Our ref: RA/2019/140142/01-L01
Your ref: 2019/91333
Date: 31 May 2019

PROPOSAL: ERECTION OF SINGLE STOREY TEMPORARY OFFICE
ACCOMMODATION INCLUDING ASSOCIATED WELFARE
FACILITIES AND INFRASTRUCTURE

LOCATION: CUMMINS TURBO TECHNOLOGY, ST ANDREW'S ROAD,
HUDDERSFIELD, HD1 6RA

Environment Agency position

Sheet Name
Proposed Layout - Ultima
Modules Complex - Including
a range of Vision Modules.

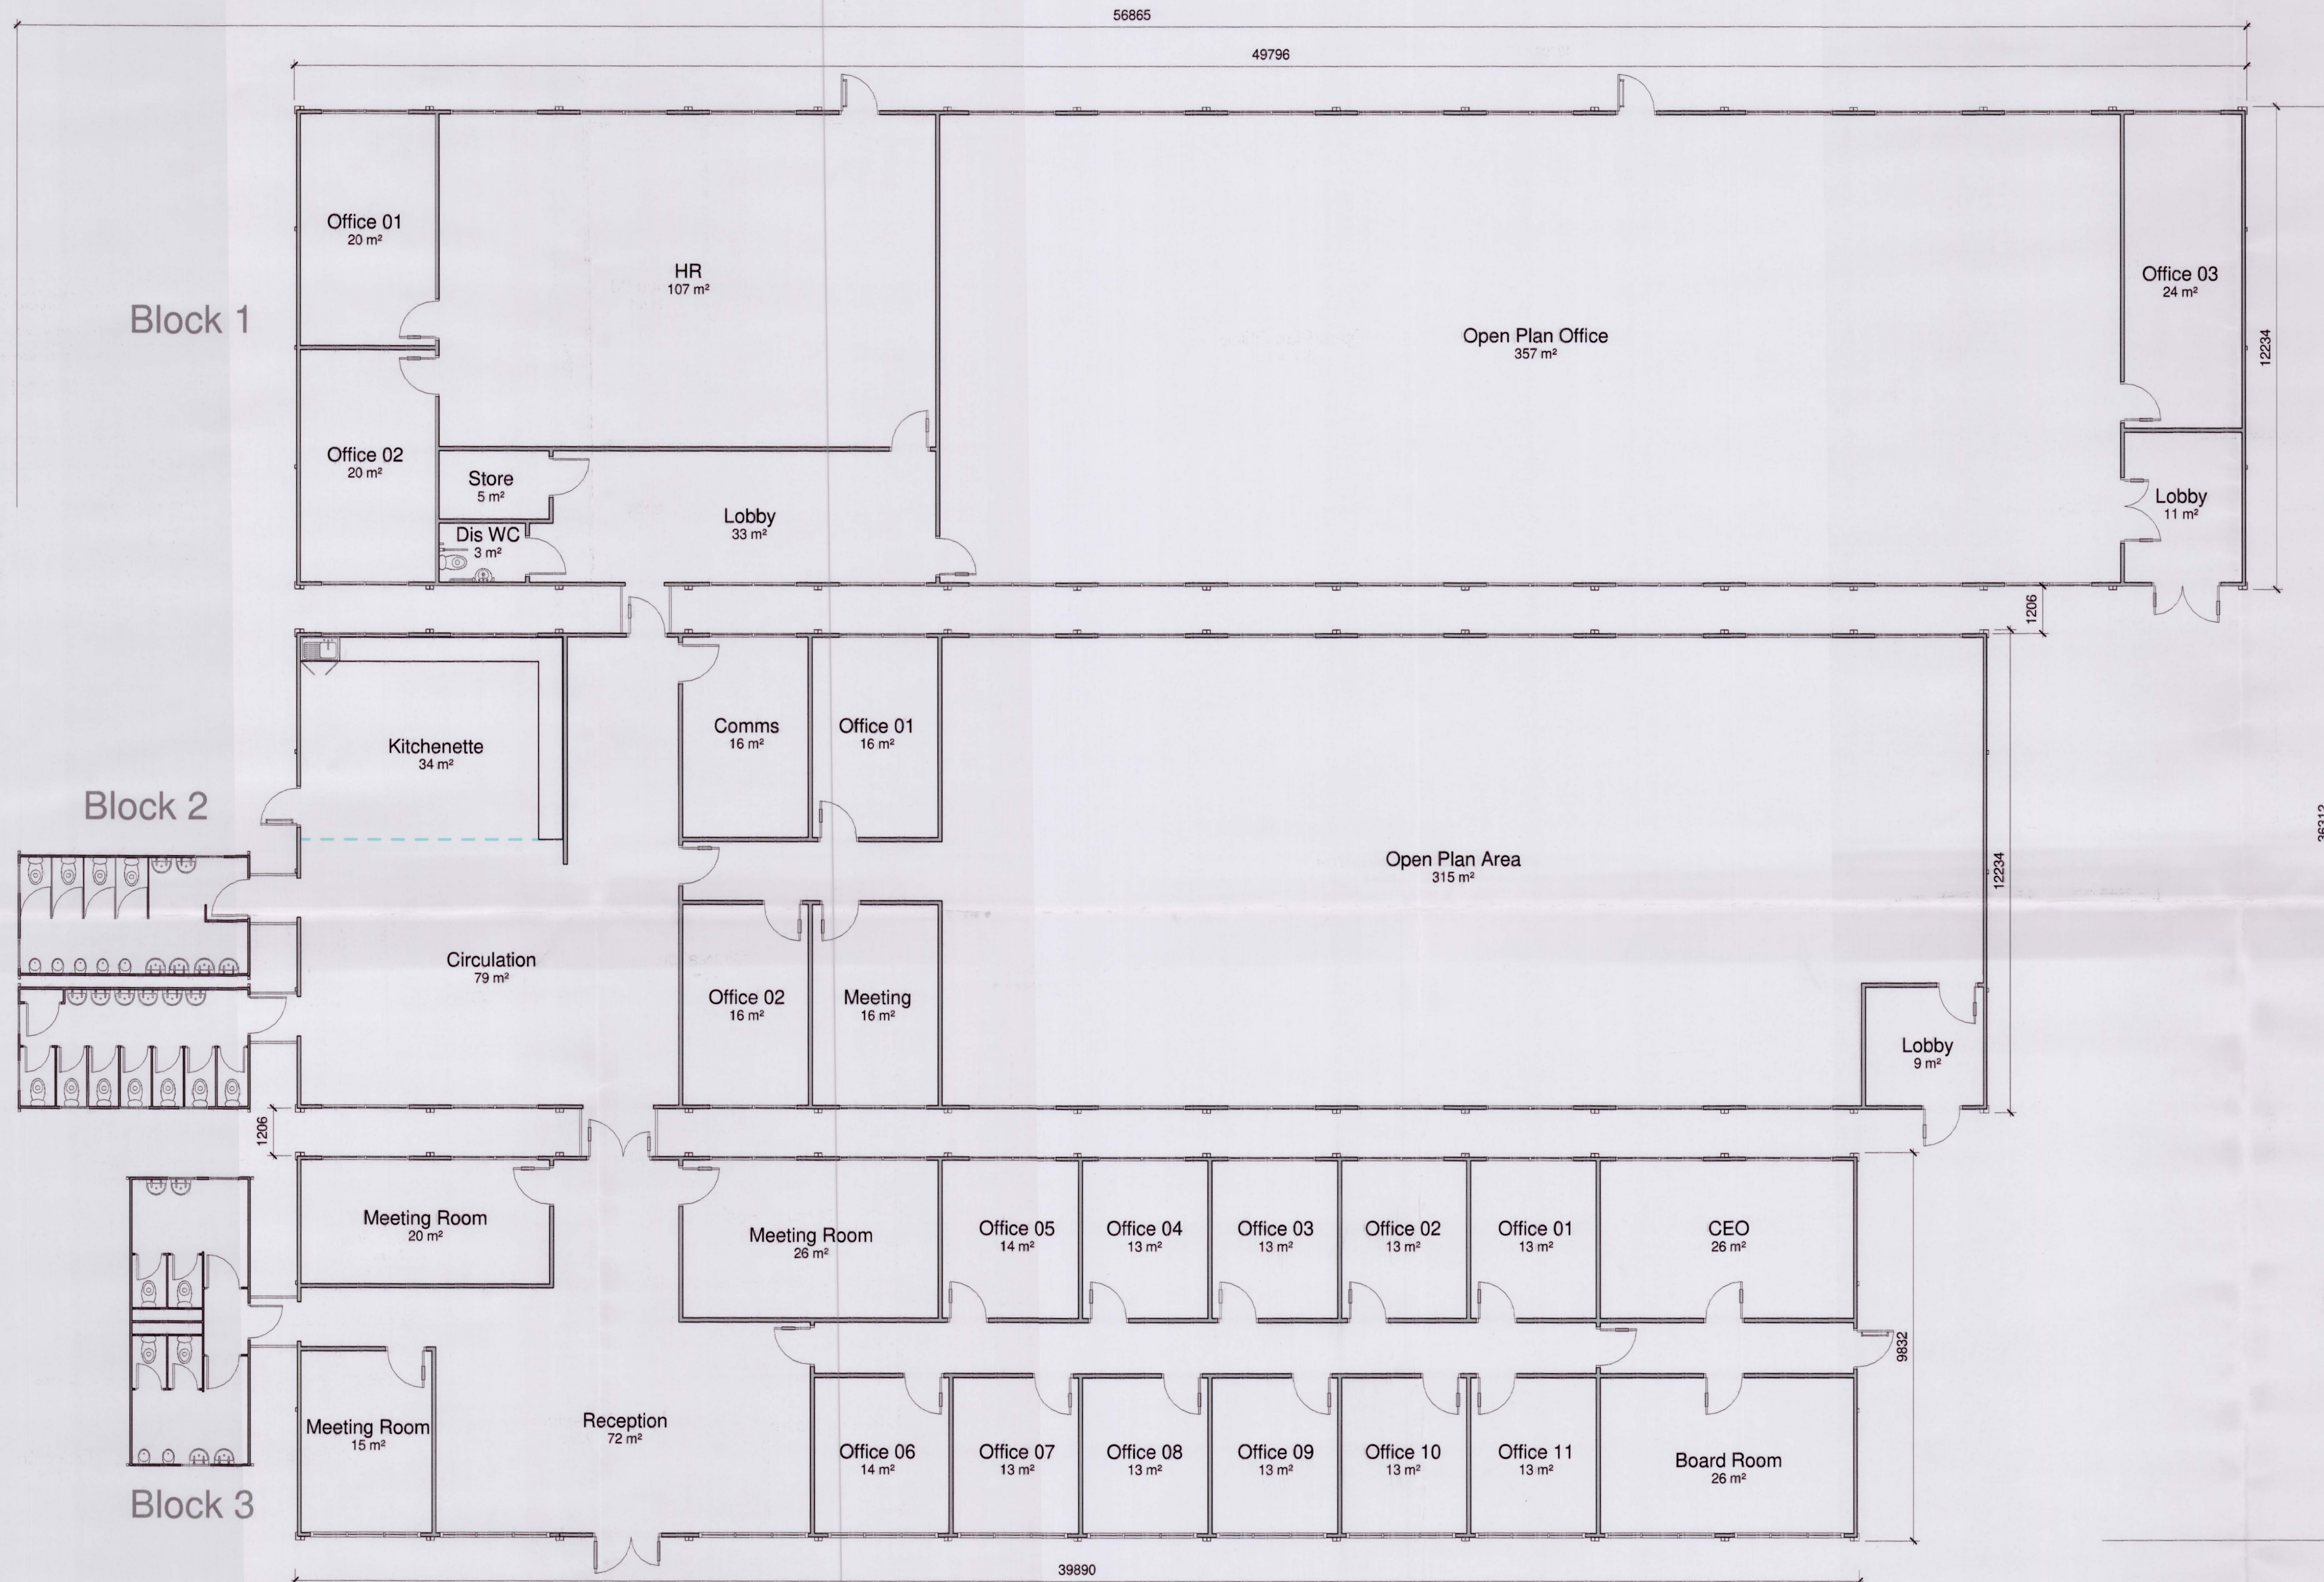
It is not clear how far the modular buildings are from the River Colne, the FRA needs to indicate the distance from the modular buildings to the top of the high ground adjacent to the Main River Colne.

The modular buildings are single storey without an upper flood place of safety and within flood zone 3. The FRA needs to demonstrate that the occupants can remain safe for the development lifetime incorporating allowances for climate change for all sources of flood risk with sufficient flood risk mitigation up to the design flood level and specified arrangements for safe access and egress.

MODELLED 1 IN 100 + 10% CC FLOOD EXTENT

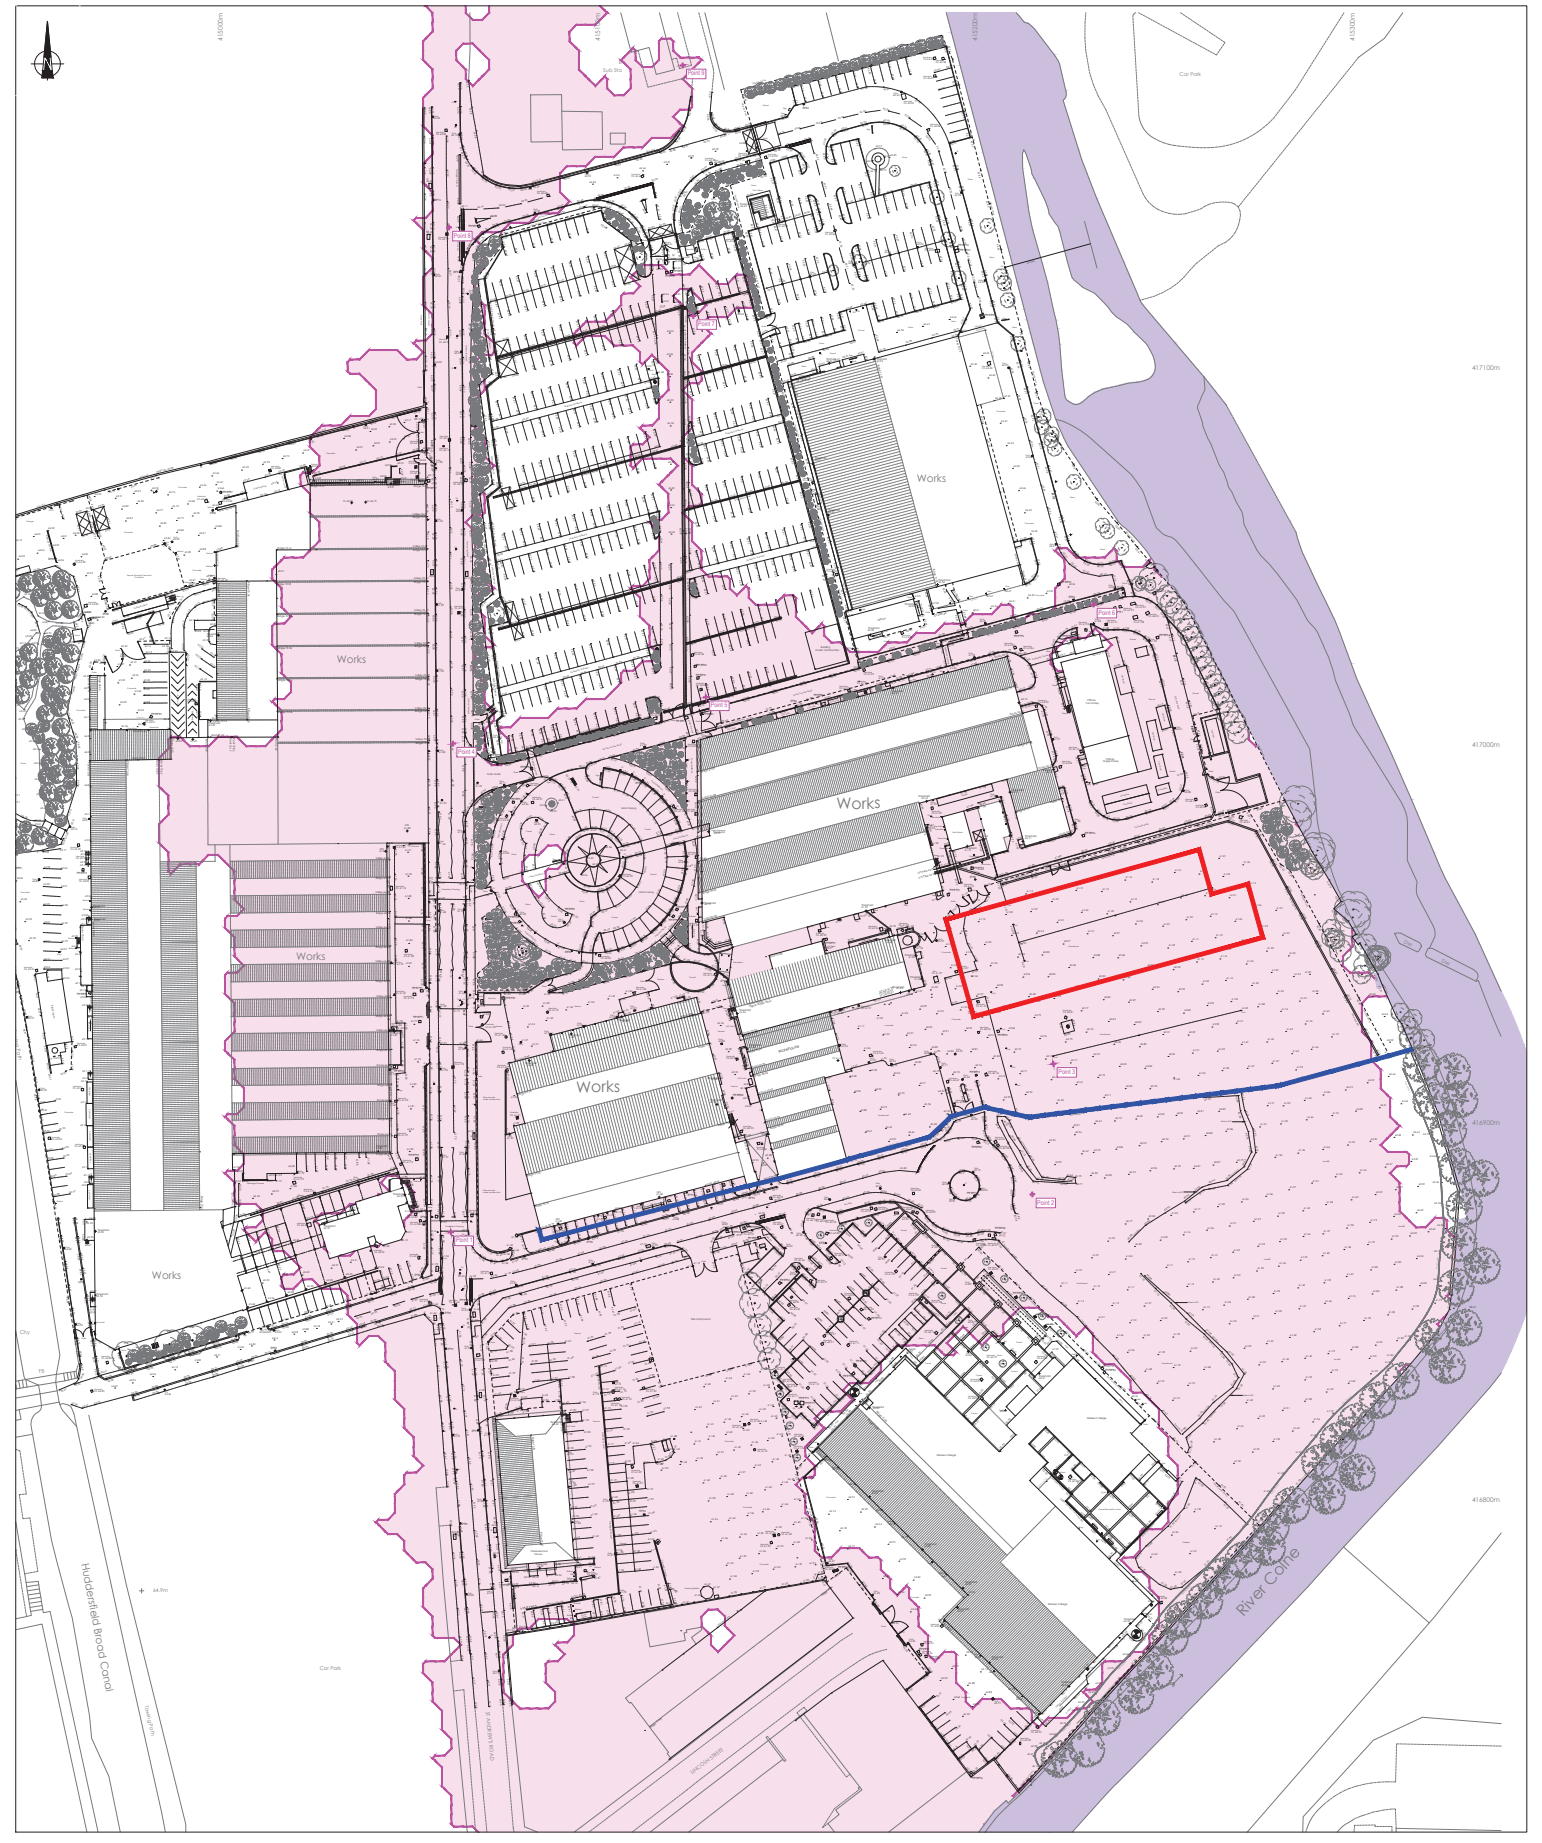
The FRA indicates that the site is protected by a 1 meter flood defence wall, however our information shows that there is just high ground alongside the side of the river in this location and no flood defences. The FRA indicates demountable flood barriers above the height of the wall.

It is not clear what height the finished floor level of the modular buildings will be set to, the FRA needs to confirm this in meters above ordnance datum (mAOD) along with a topographic survey showing the ground levels in mAOD.

The finished floor levels should be above the 1% probability or 1 in 100 year modelled flood level plus in addition the allowance for climate change and a further 300mm.

Compensatory storage is required for any development within flood zone 3. The site is within flood zone 3 therefore you will need to assess this requirement. If the modular buildings allow the free flow of water beneath them without any obstruction to flow or opportunity for debris to collect to the 1 in 100 or 1% probability modelled flood level plus climate change plus 300mm then compensatory storage may not be required.
